# KITTTITAS COUNTY COMMUNITY DEVELOPMENT SERVICES

November 14, 2022

## **RE: RU-22-00004 Marlatt – Deemed Incomplete – Request for Additional Information**

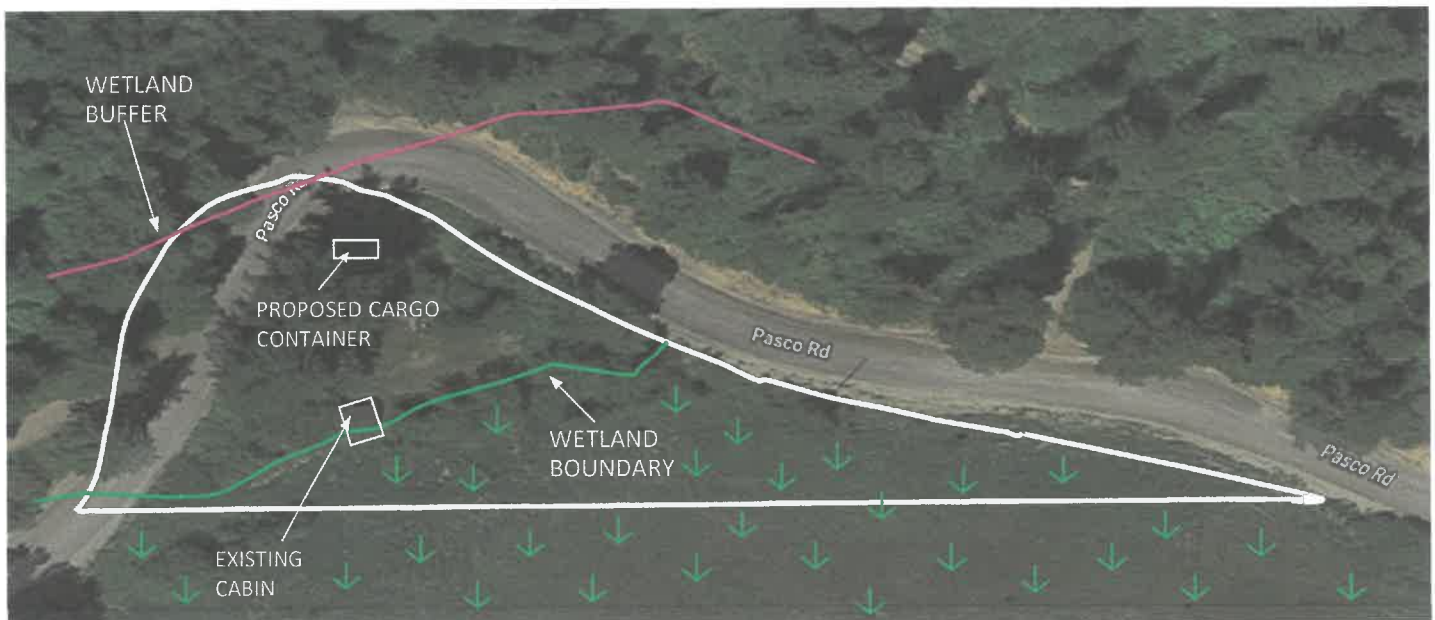
Kittitas County Community Development Services (CDS) received your Reasonable Use Exception request on October 28, 2022 to provide relief to a 150 foot and 15-foot building setback from a Category II Wetland for the placement of a storage container and cabin. Based on the wetland report done by Grette Associates in October of 2022, it mentions that all structures would be outside of the wetland itself once a 15-foot deck was removed from the cabin. All site plans provided appear to show structures in the wetland boundary itself (not buffer). As such Kittitas County deems your Reasonable Use application **Incomplete**.

1. An updated site plan that shows all structures will be outside of the wetland boundary
- OR
2. A reason for the unavoidable impacts to the wetland and mitigation for the unavoidable impacts under KCC 17A.07.070
